KITTITAS COUNTY

MEMORANDUM

TO: All Staff
FROM: Public Works Plan Review Team
DATE: August 24, 2026
SUBJECT: SP-26-00007 Schultz

**SCHULTZ SHORT PLAT
PART OF SECTIONS 26 & 35,
TOWNSHIP 19 NORTH, RANGE 17 EAST, W.M.
KITITAS COUNTY, WASHINGTON**

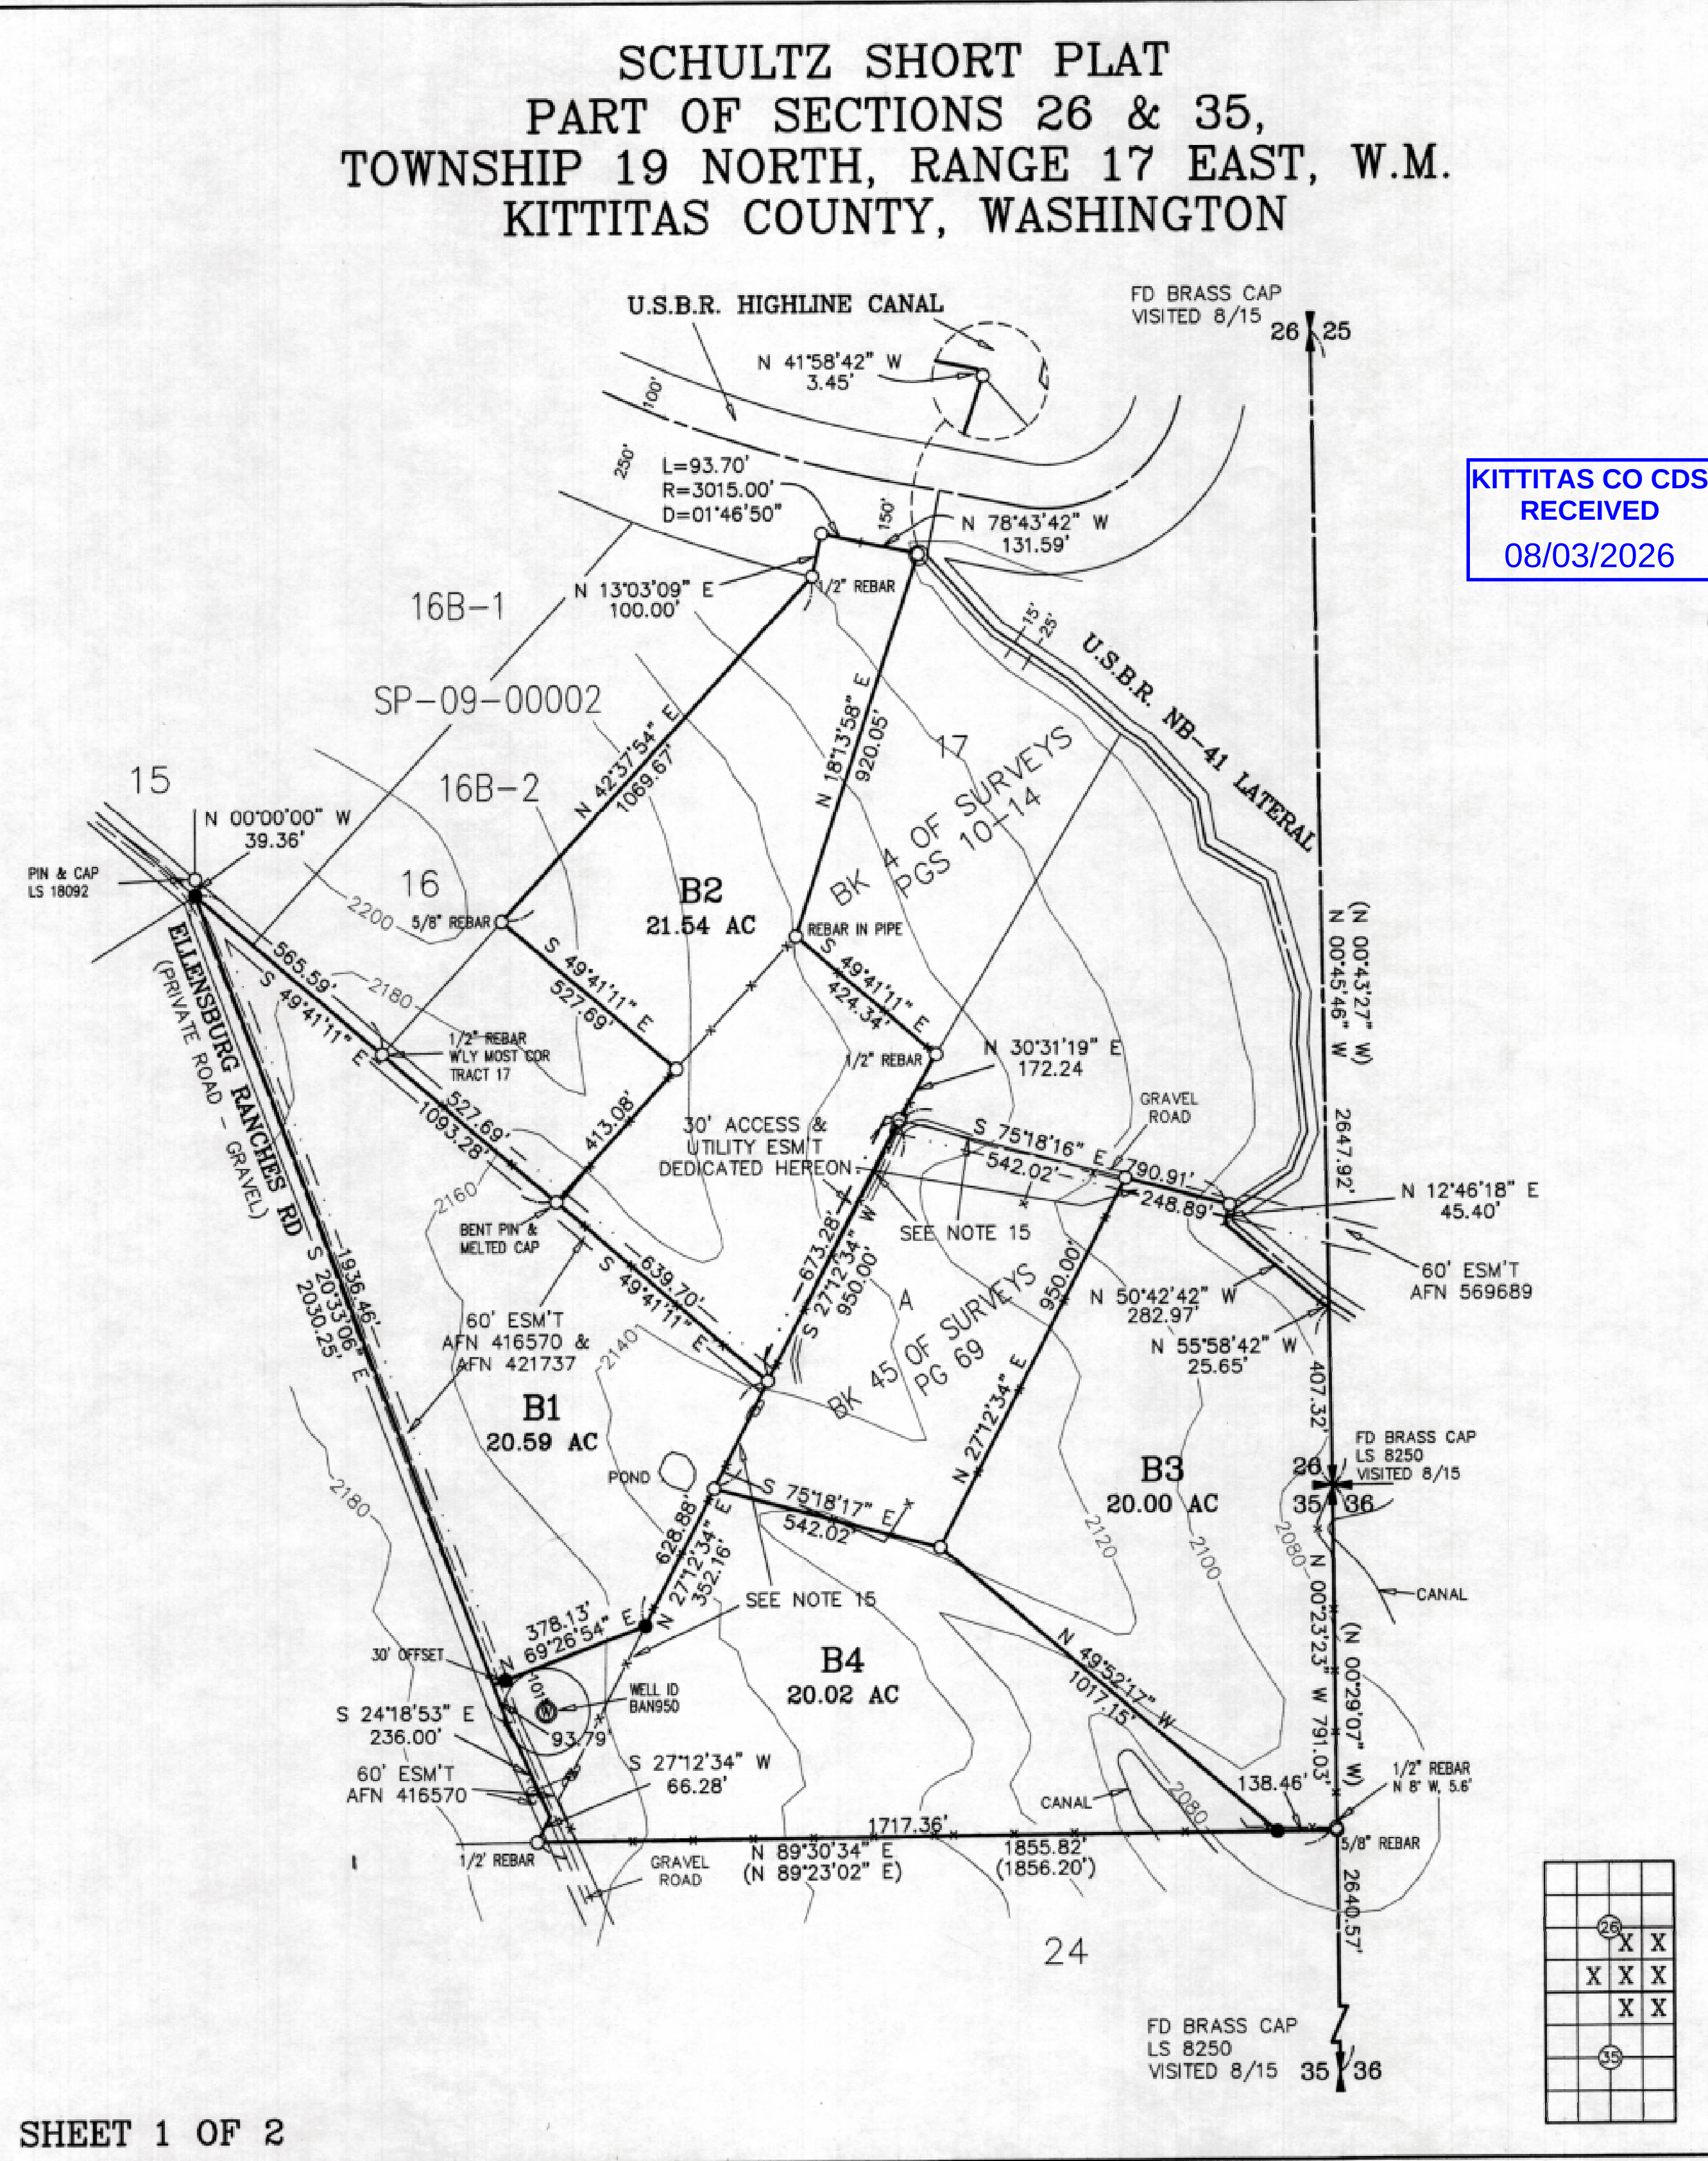
ACCESS	1. An approved access permit shall be required from the Kittitas County Department of Public Works prior to creating any new driveway access or altering an existing access. 2. Access easements for joint use driveways must be a minimum of 30 feet wide. Appears to be only a 5ft easement for lot B3. 3. Lots that access easements or rights-of-way controlled by different agencies, such as State highways, Forest Service Roads, irrigation canals, or railroads will require separate access approvals from those agencies. A copy of the access approval shall be submitted to the County prior to issuance of the County's access permit. The County cannot grant access to roads or easements it does not control (KCC 12.05.030(G)). 4. Maintenance of driveway approaches shall be the responsibility of the owner whose property they serve. The County will not maintain accesses. 5. Any further subdivision or lots to be served by proposed access may result in further access requirements. See Kittitas County Road Standards. In addition to the above-mentioned conditions, all applicable Kittitas County Road Standards apply to this proposal. Access is not guaranteed to any existing or created parcel on this application.(RC)
